Fosse Green Energy

EN010154

9.31 Applicant's Response to Deadline 5
Submissions

12 May 2026

EN010154/APP/6.2.

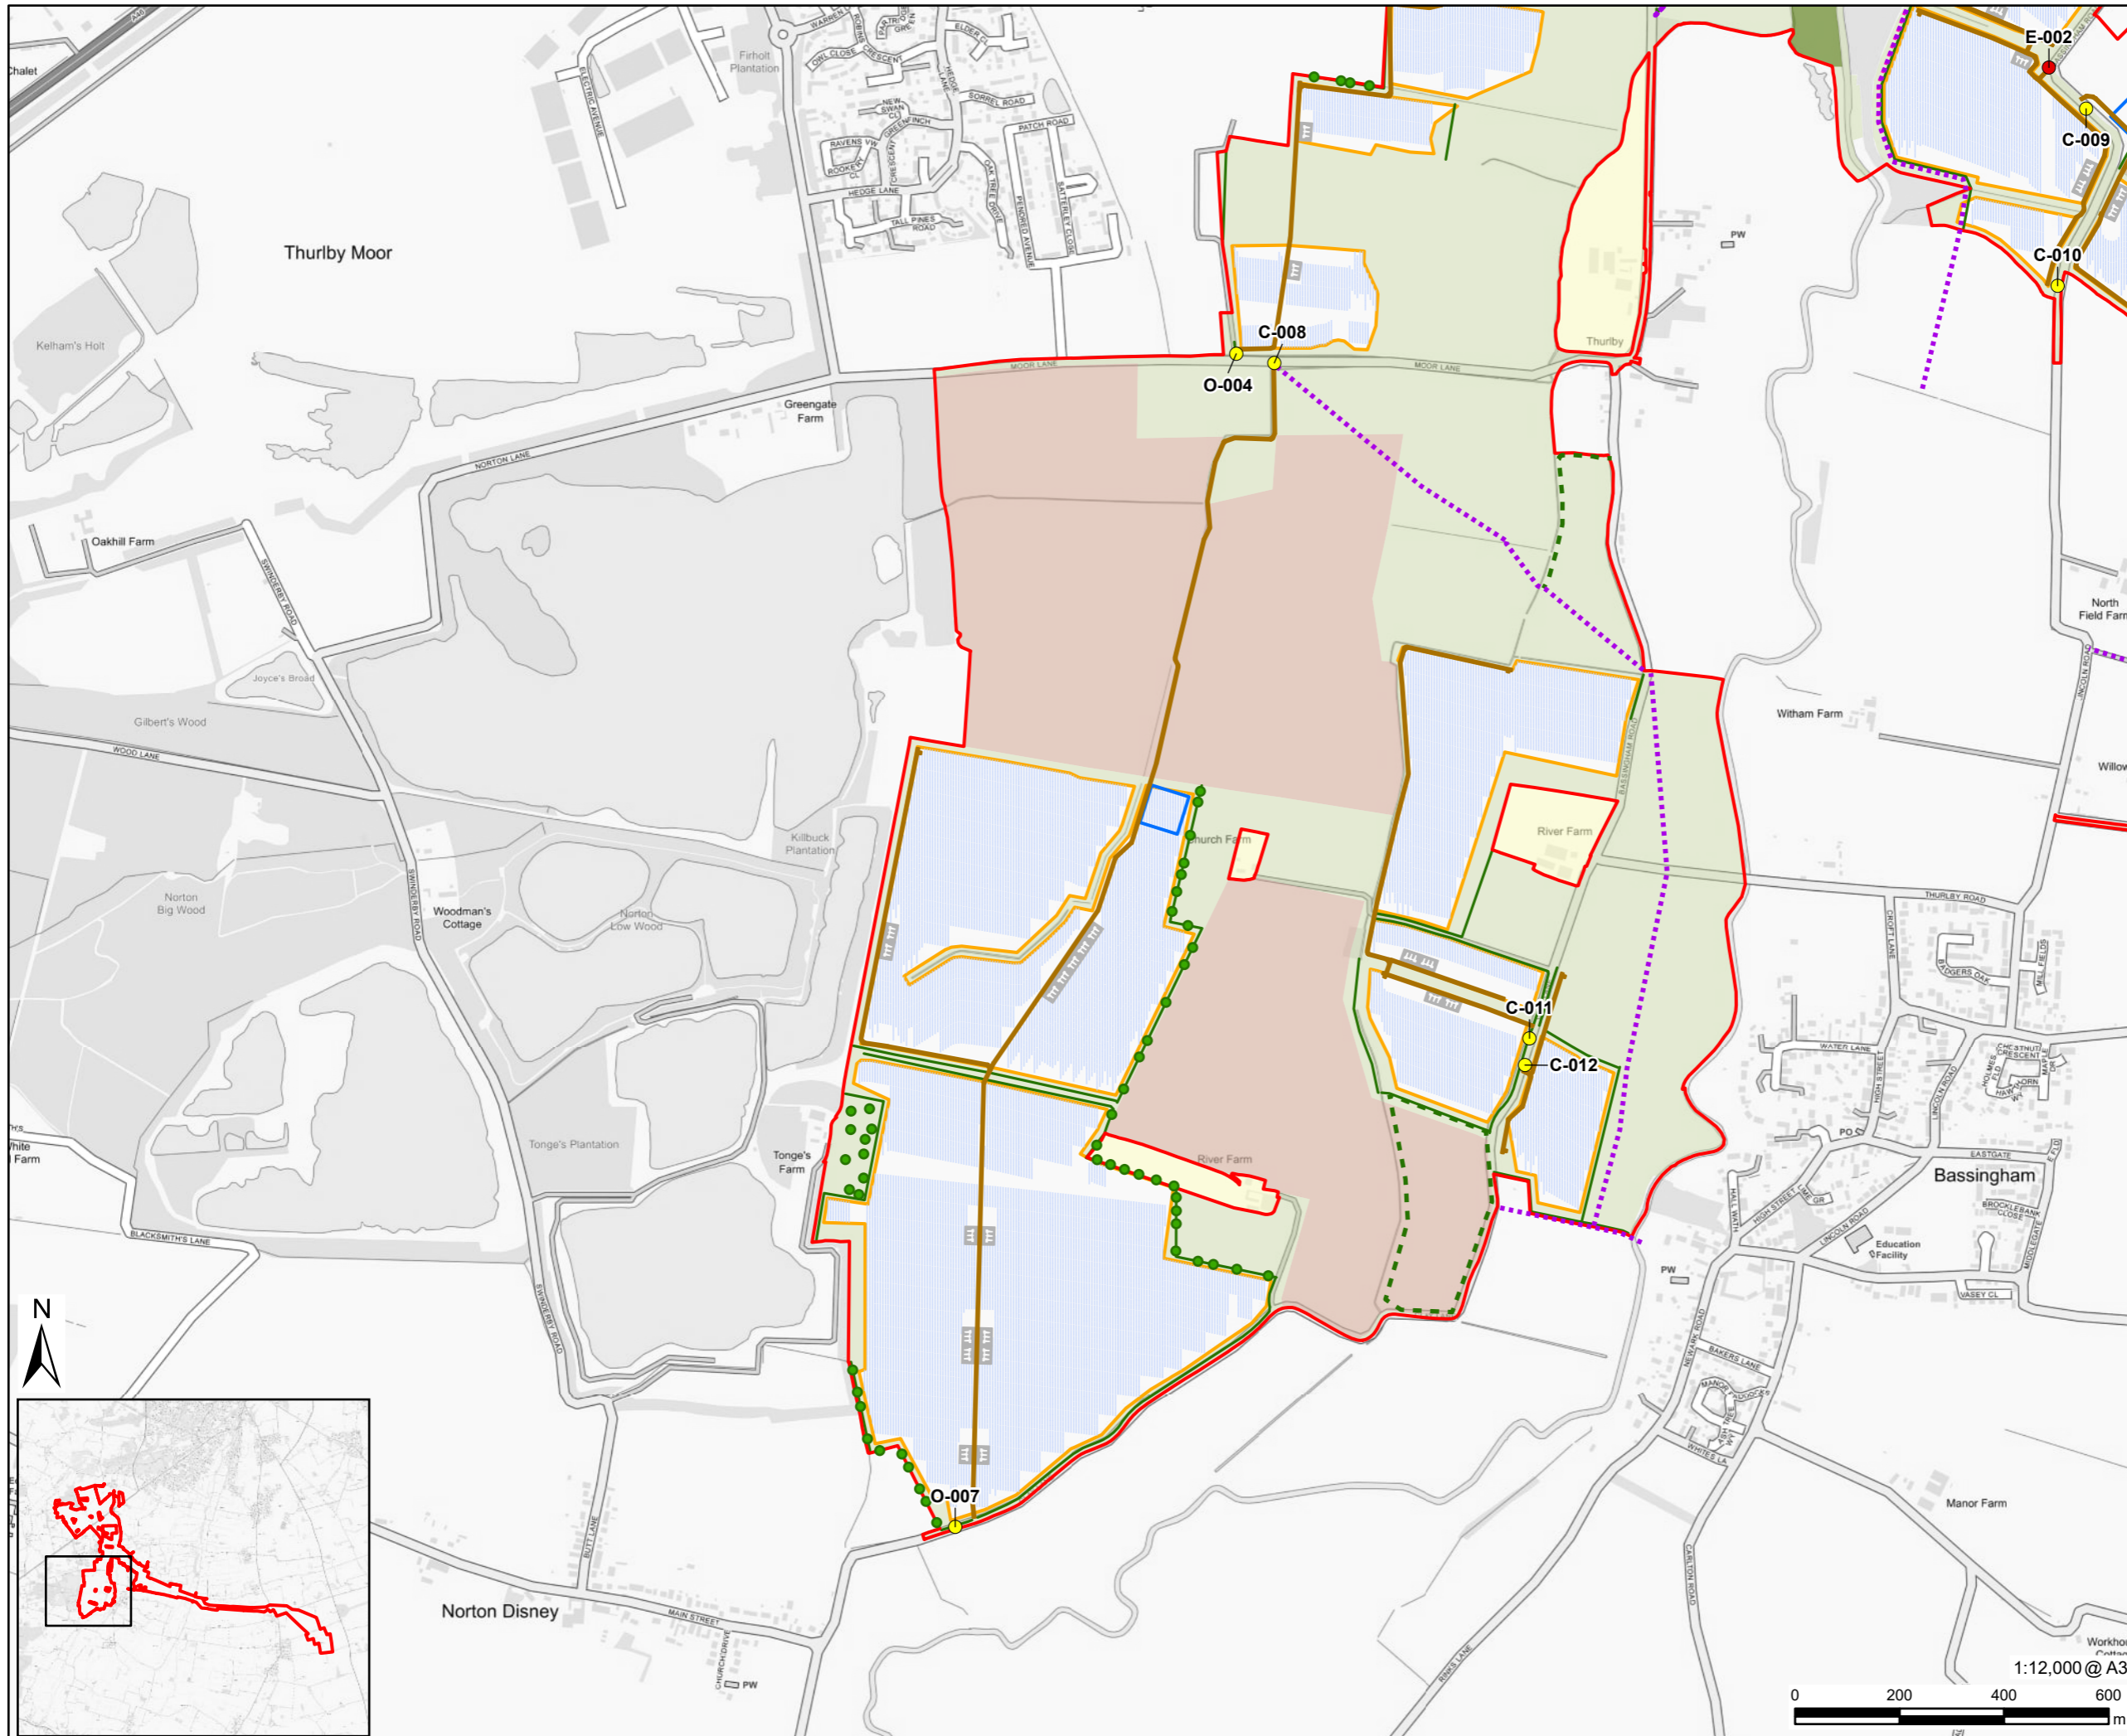
Interested Party	Theme	Comments from any party on any submissions and any information received at deadline 4	Applicant Response
LCC	Comments on D4 documents - Layout	Site Layout Plan Revisions - Indicative Fixed South Facing Layout (Rev 3) and Indicative Single Axis Tracker Layout (Rev 3) [REP4-006 & REP4-007, respectively) LCC assumes that the overall red line boundary remains unchanged, and thus LCC's previous comments in respect of minerals & waste safeguarding remain unchanged.	The assumption that the DCO Site red line boundary remains unchanged is correct. The Applicant's position regarding minerals and waste safeguarding are set out the Applicant's Response to Deadline 4 Submissions [REP5-025], the Applicant's Response to the Examining Authority's First Written Questions [REP2-029] and the Applicant's Response to Deadline 2 Submissions [REP3A-025].
LCC	Comments on D4 documents - FCEMP	Framework Construction Environmental Management Plan (Rev 5) [REP4-009] LCC notes and appreciates the addition of paragraph 2.2.3 which states the applicant will inform LCC of the date of final commissioning once it has occurred. Section 2.9: Recovery, Recycling and Disposal of Waste – No changes to comment on here, but we note that the Table of Contents mistakenly labels this as 'Section 2.8'. In respect of archaeology LCC's previous comments stand, including that 'The full extent of any preservation in situ areas or areas identified for further archaeological work will need to be fenced off to ensure that there are no groundworks, plant movement, storage or any other developmental works which may cause damage to the currently surviving archaeology.' Within Table 2, cultural heritage, CH-C1 states that 'The detailed CEMP(s) will include an action plan detailing the required mitigation in the event that unplanned activities threaten the preservation of known buried archaeological remains.' Again, this will also need to include unevaluated areas as well as known archaeologically sensitive areas. This document makes reference to Environmental and Ecological Clerks of Work, as stated in our previous comments, an Archaeological Clerk of Works is also required.	Regarding an Archaeological Clerk of Works, it should be noted that CH-C1 of the Framework CEMP [REP5-011] notes that "If deemed necessary, an Archaeological Clerk of Works can be agreed." Matters of temporary or permanent fencing to protect known or potential buried archaeological remains are referenced in the draft Framework WSI [REP3A-027] (at paragraph 3.19) The Framework CEMP [REP5-011] correctly identifies the section 'Recovery, Recycling and Disposal of Waste' as Section 2.8 within the Table of Contents and within the document itself.
